PRELIMINARY DRAINAGE REPORT

GRANDVIEW RESERVE

El Paso County, Colorado

DATE:
August 11, 2021

EXISTING EX1

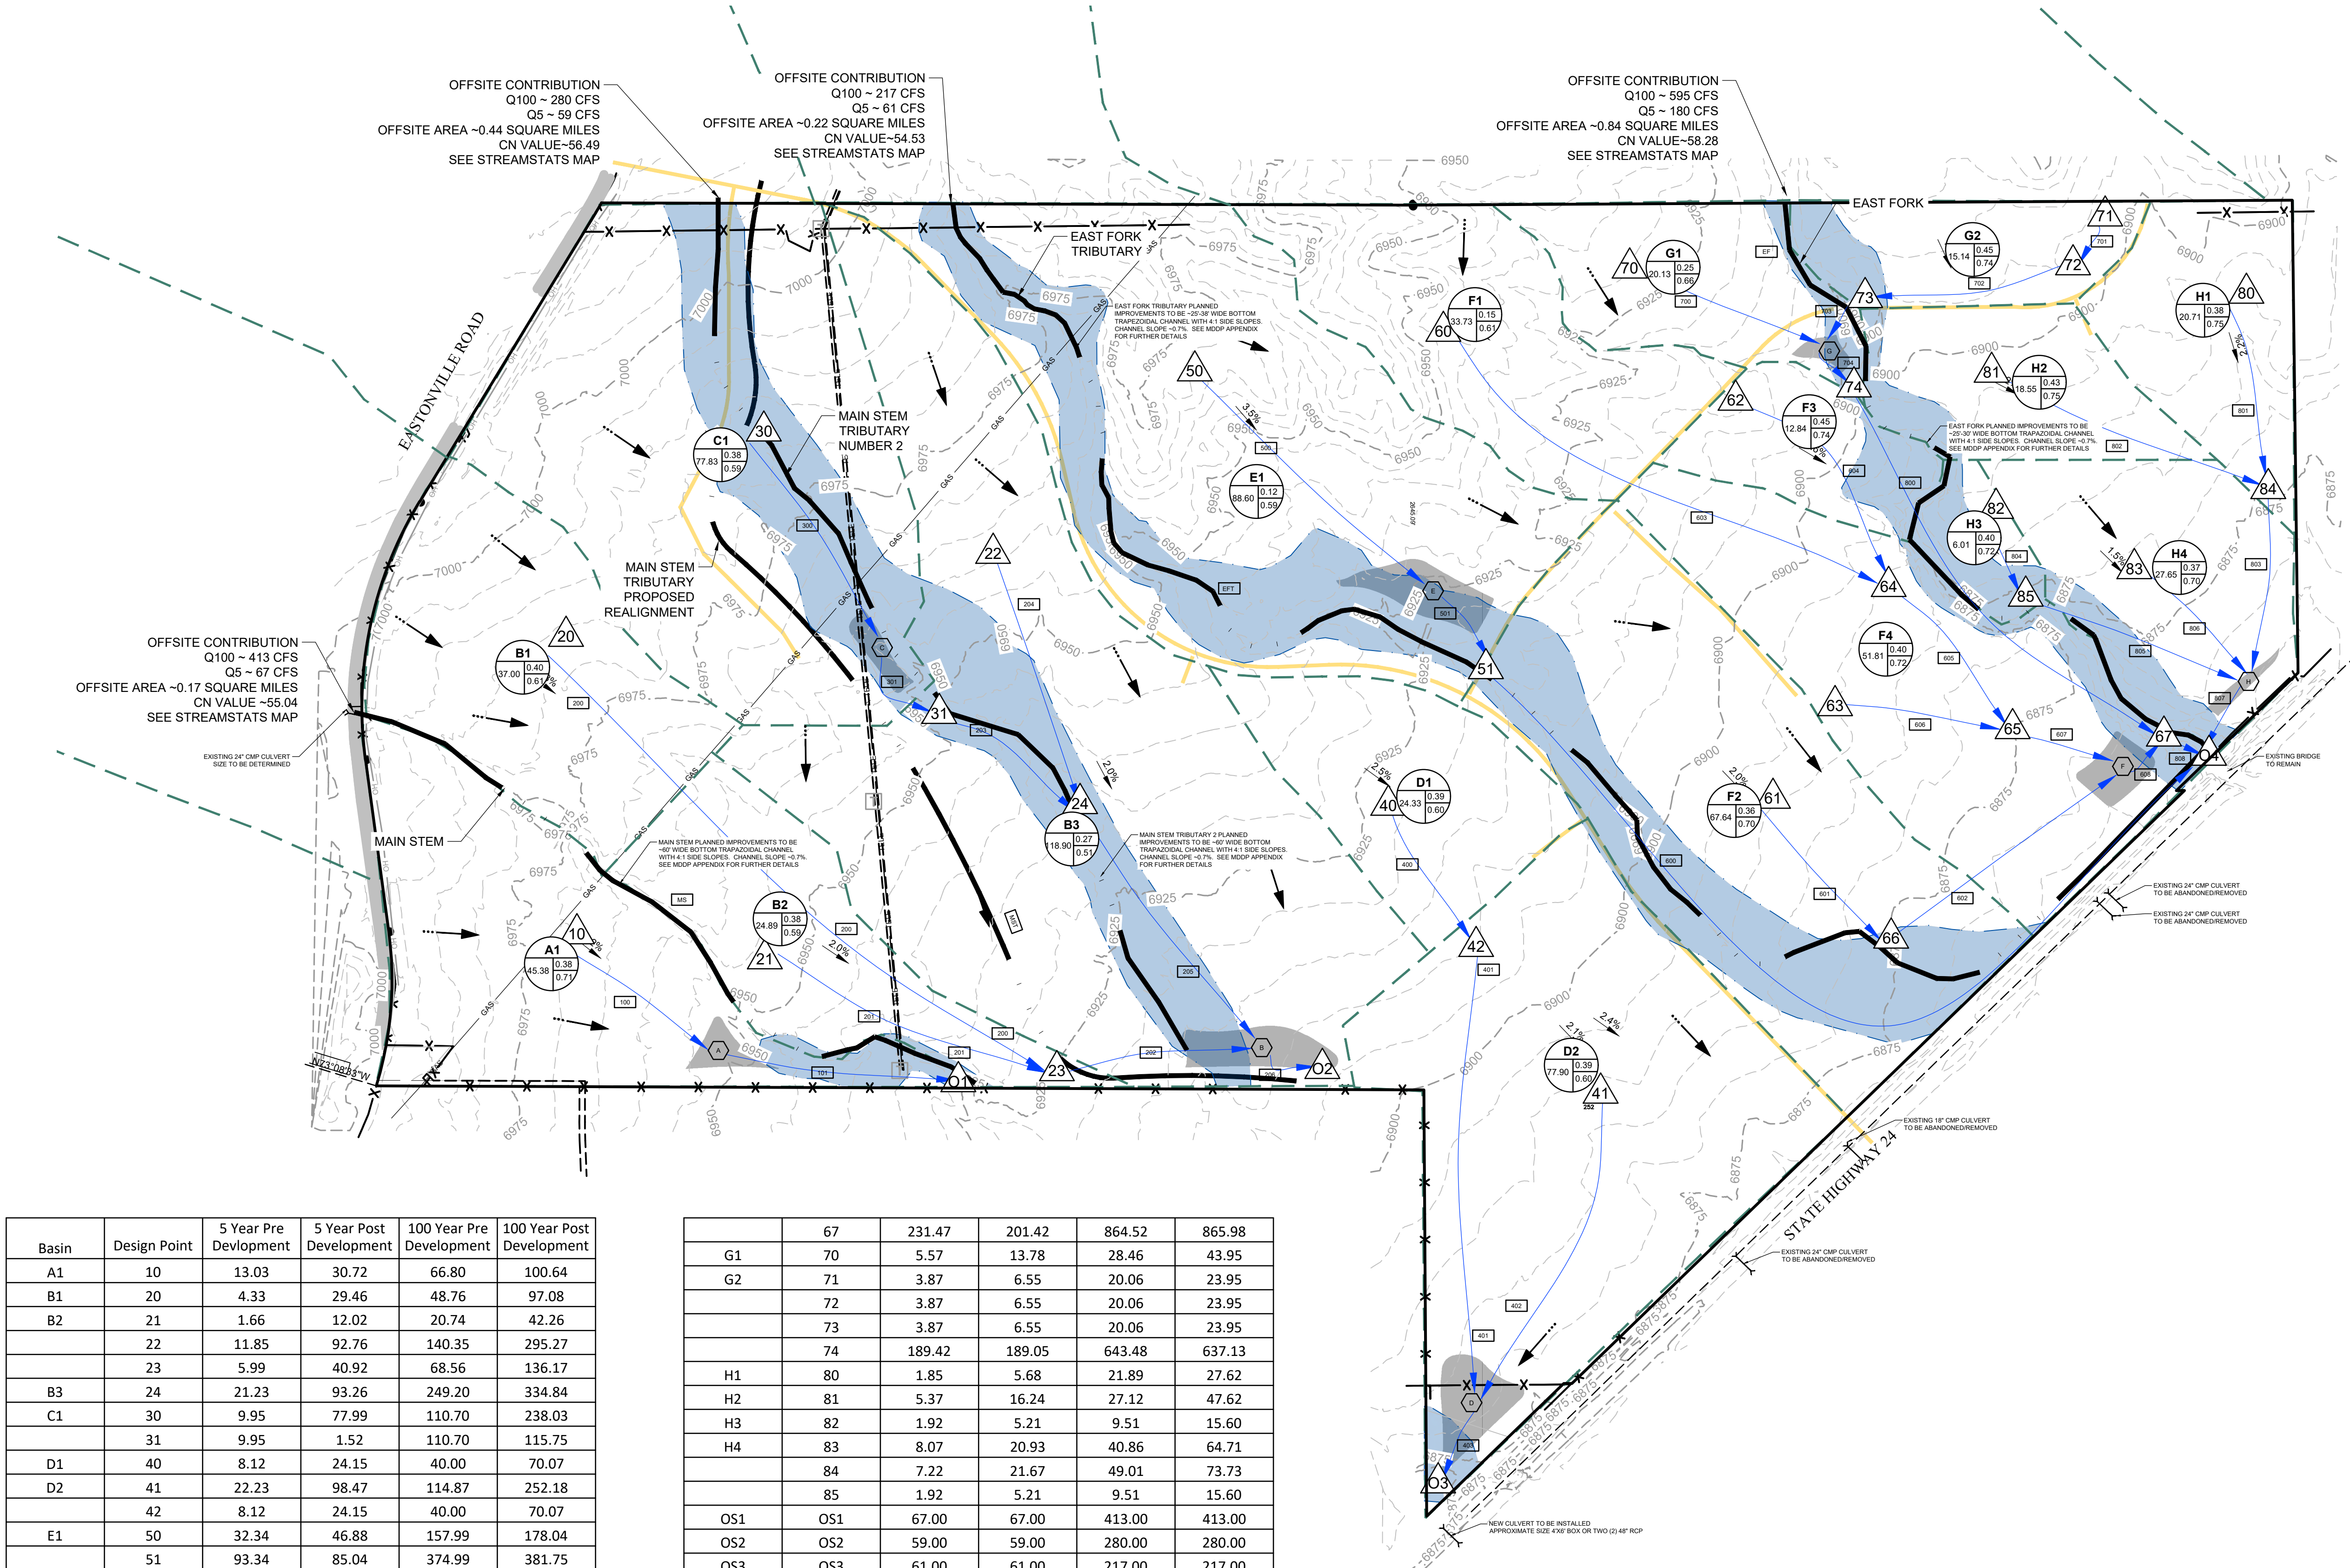
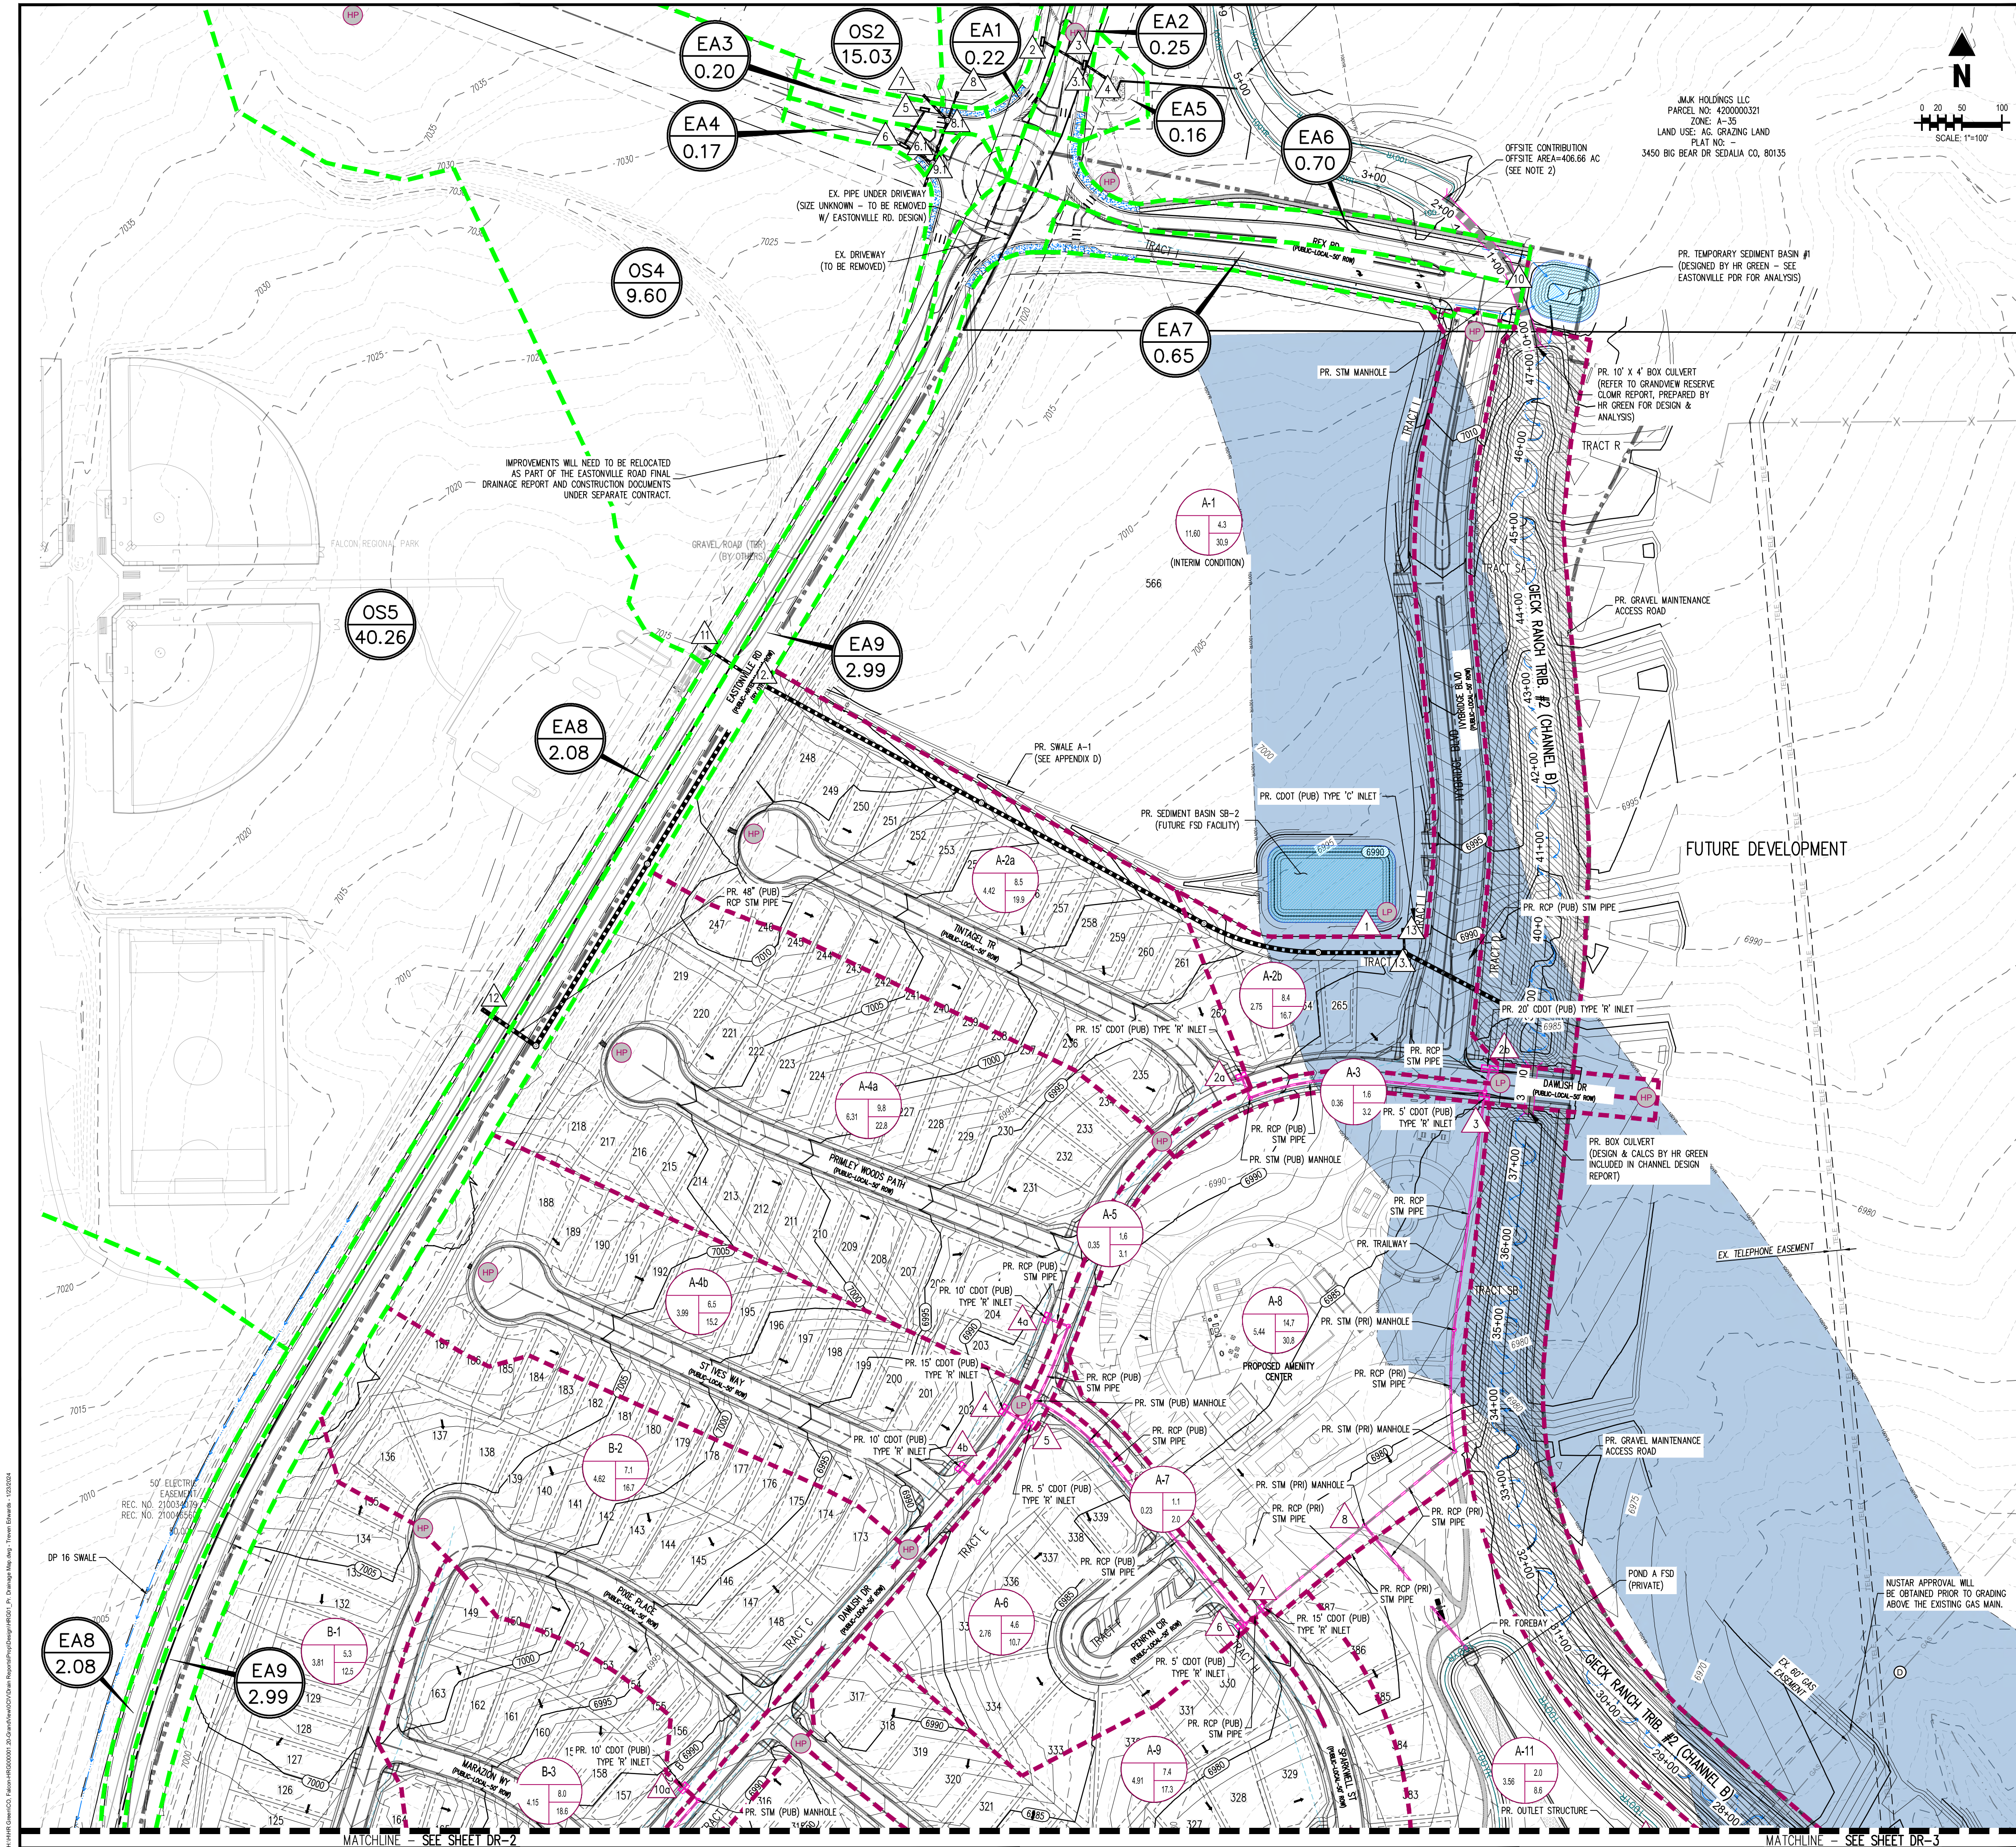
not found?

Based on the MDDP there should be at least 7 onsite and offsite existing basins

Address the additional culvert

address the flow from the additional culvert in both existing and proposed conditions

PROPOSED DRAINAGE MAP

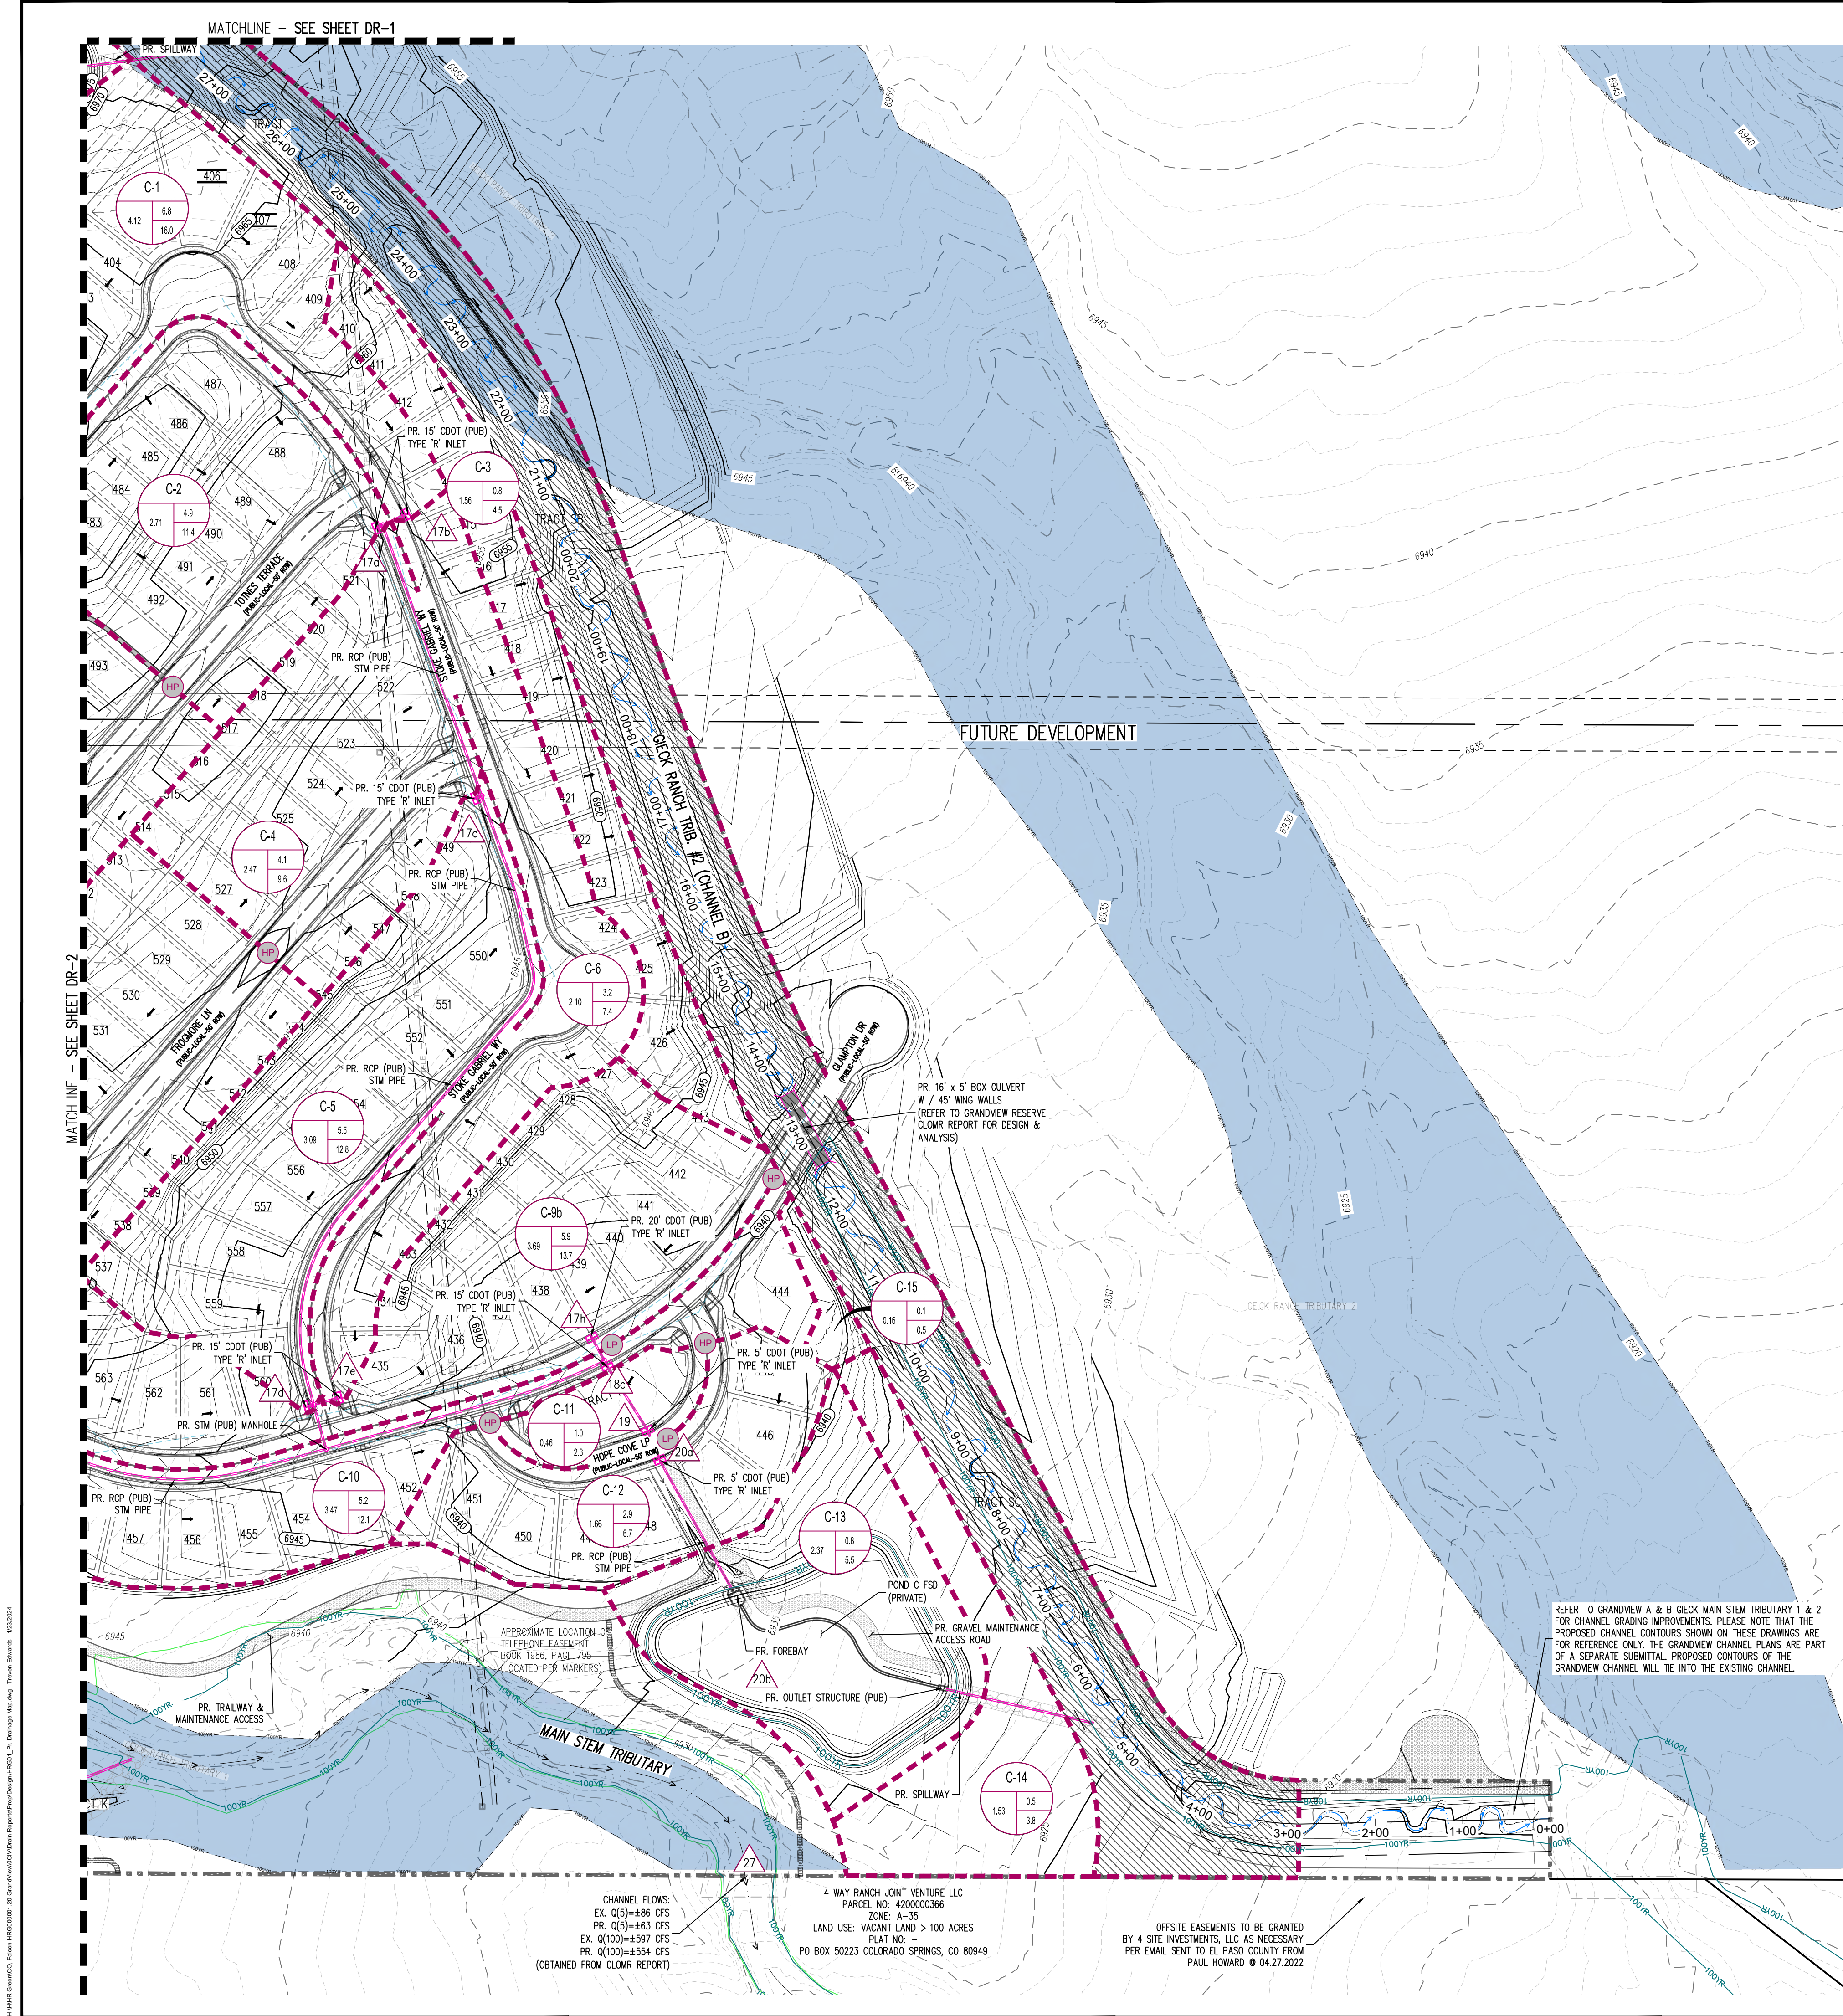
Address where overflows will go

← Address where overflows will go

← Address overflow spillway size and location

← address overflow routes

← Address overflow route

This basin needs to be split up with more design points

Address overflow route

Expand on the description - most of the area drains into a channel?

Address overflow route

Needs to be broken up
